# Roadway Plans\_V1.pdf Markup Summary

# CLEARWAY FILING NO. 2, LOT 5

# CONSTRUCTION PLANS

**STORM 4 STA 1+00.00 TO STA 2+53.69**

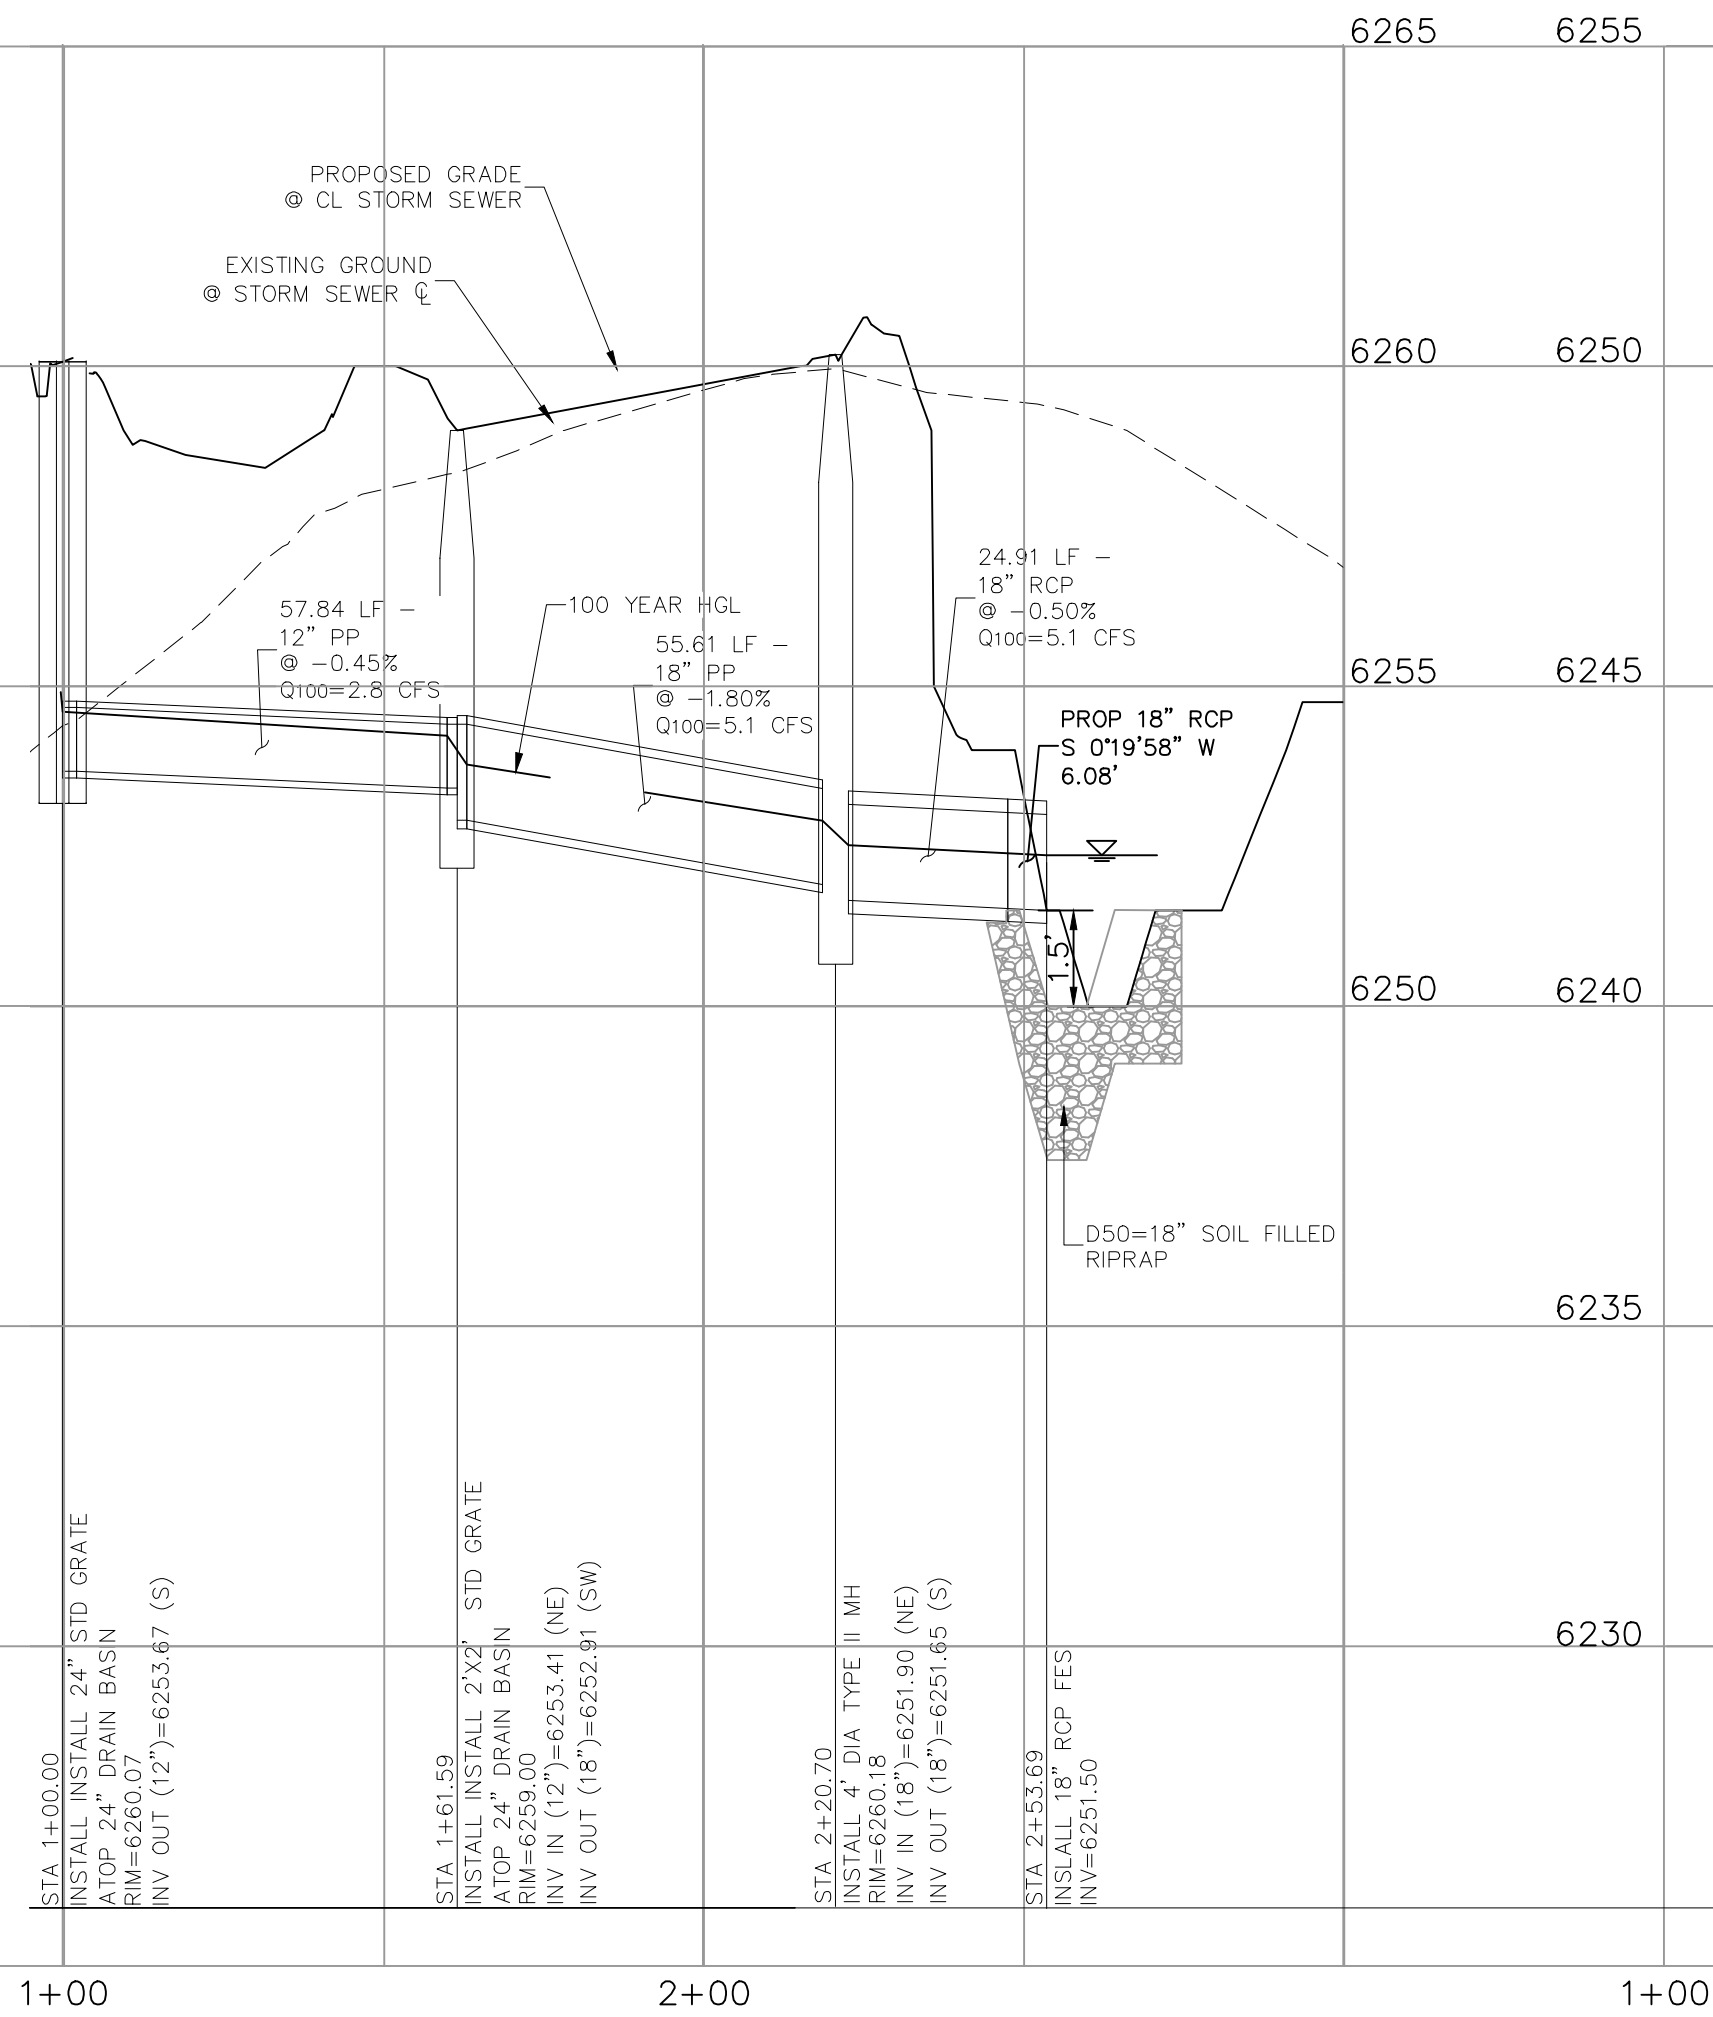
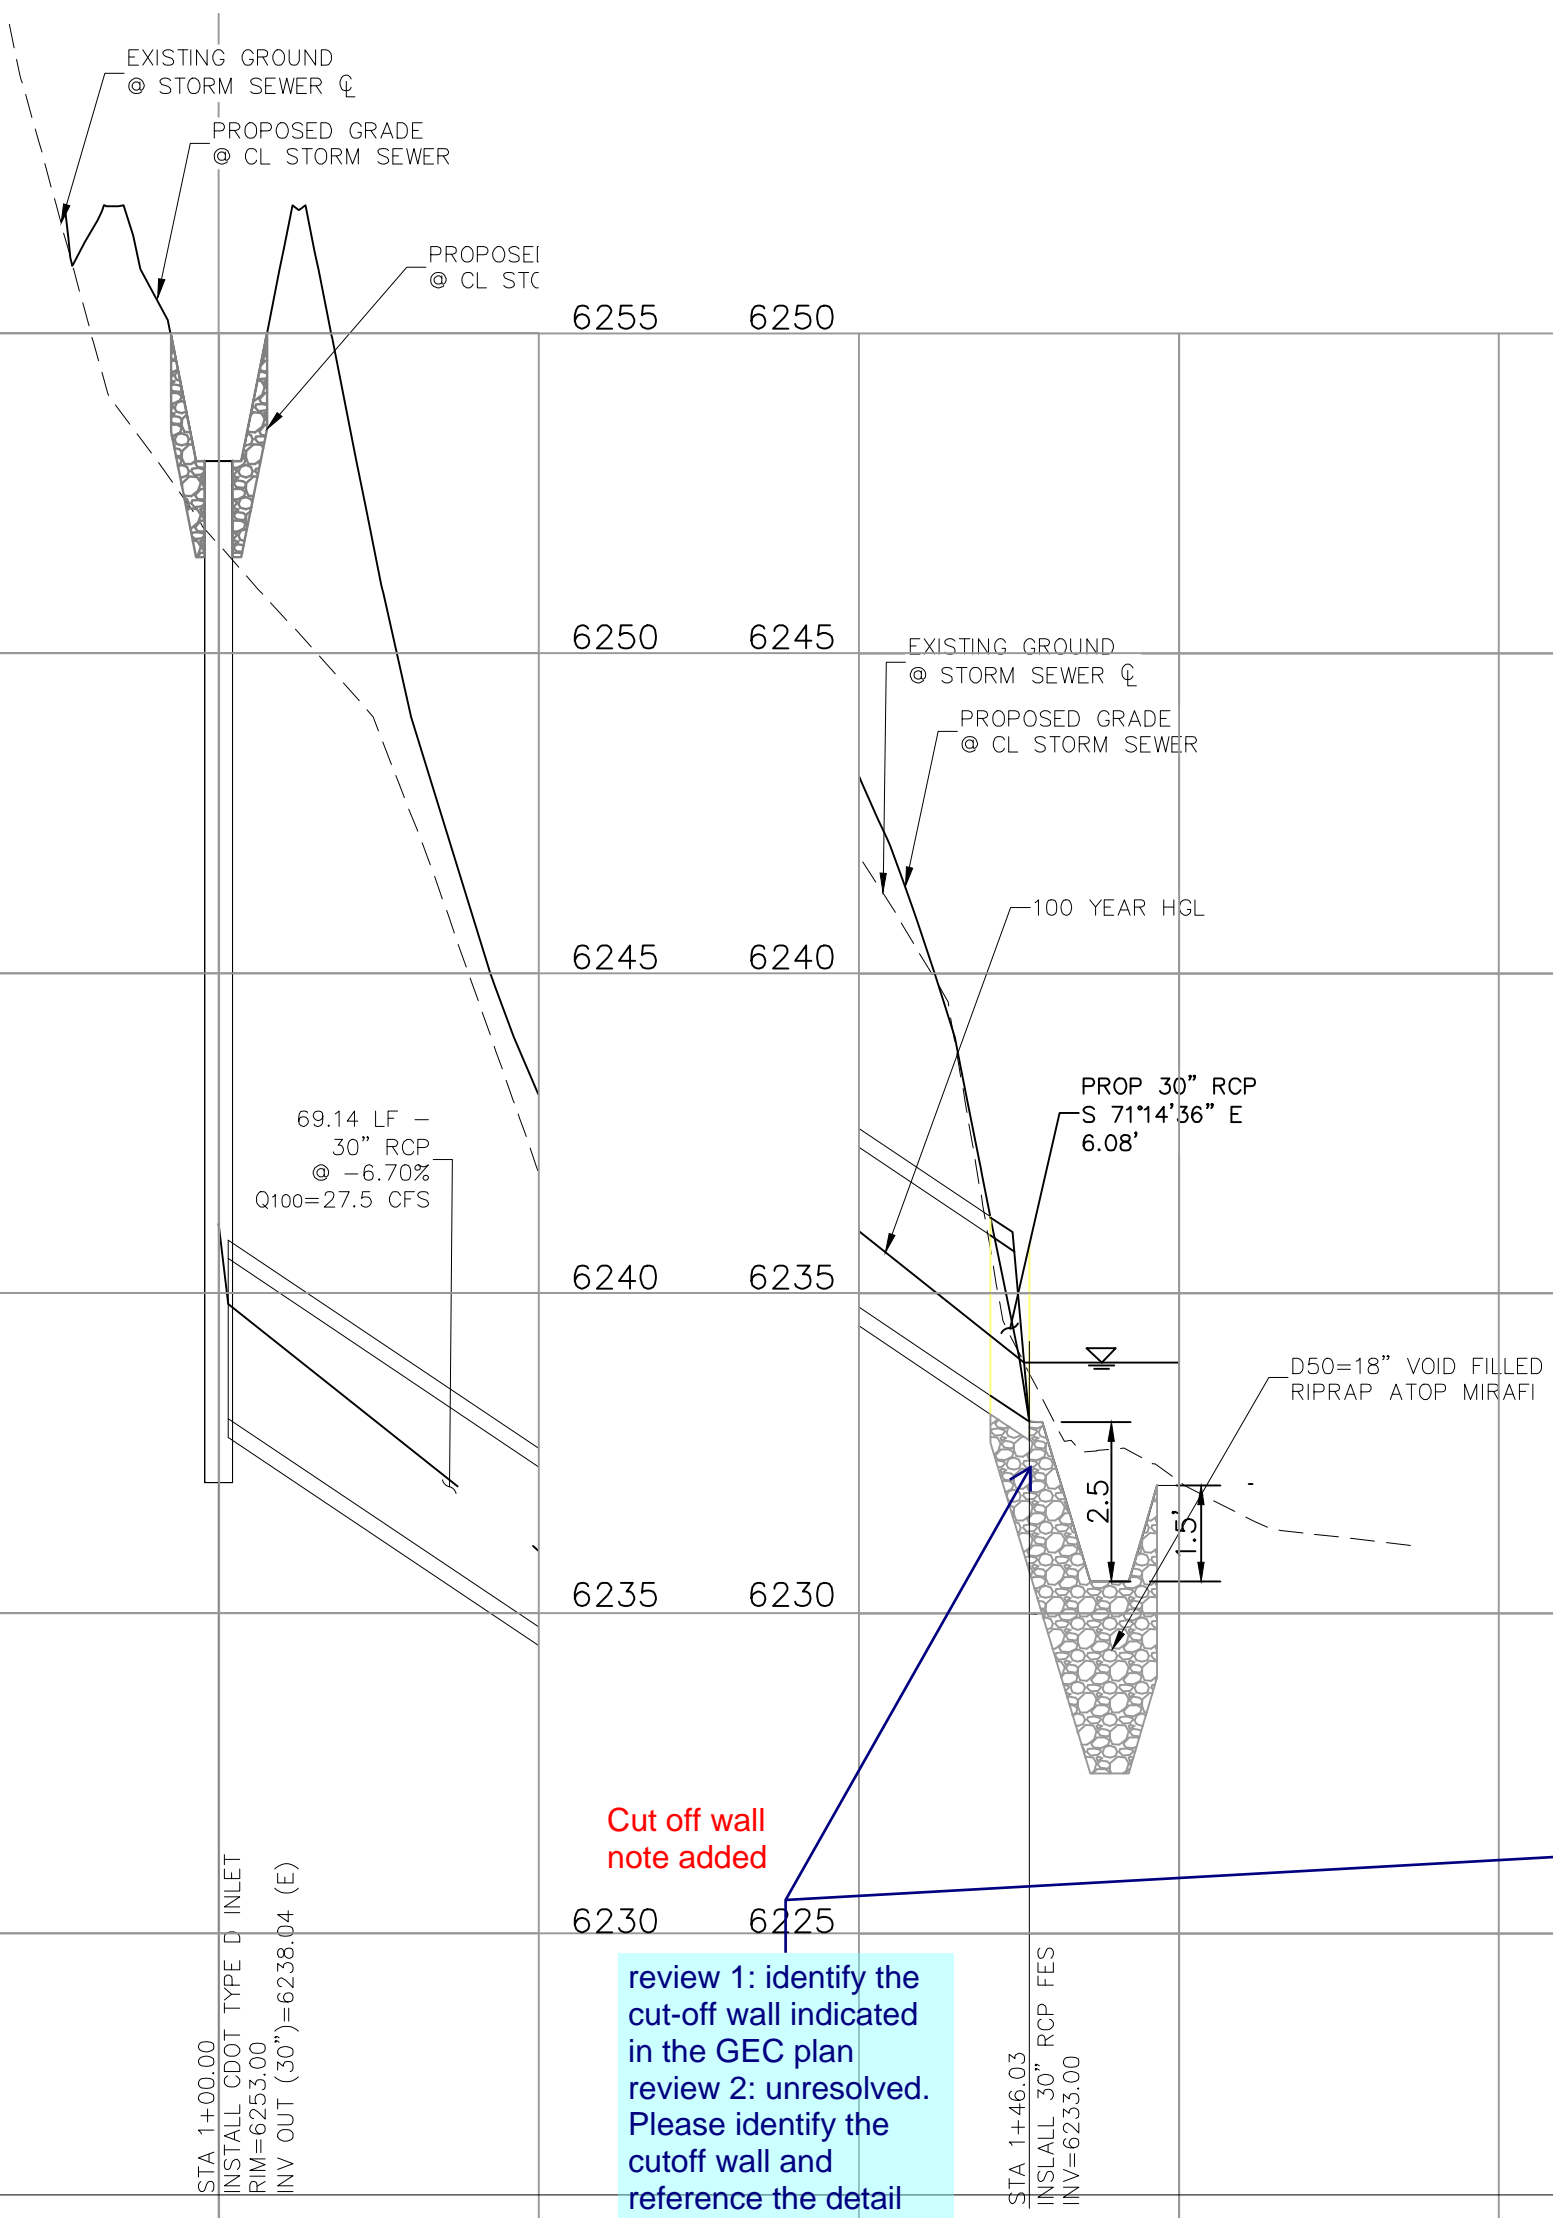
Show HGL lines on the profiles.

18" identified on the drainage plan. Revise accordingly.

identify the cut-off wall indicated in the GEC plan

clarify if there is a difference between soil filled and void filled riprap
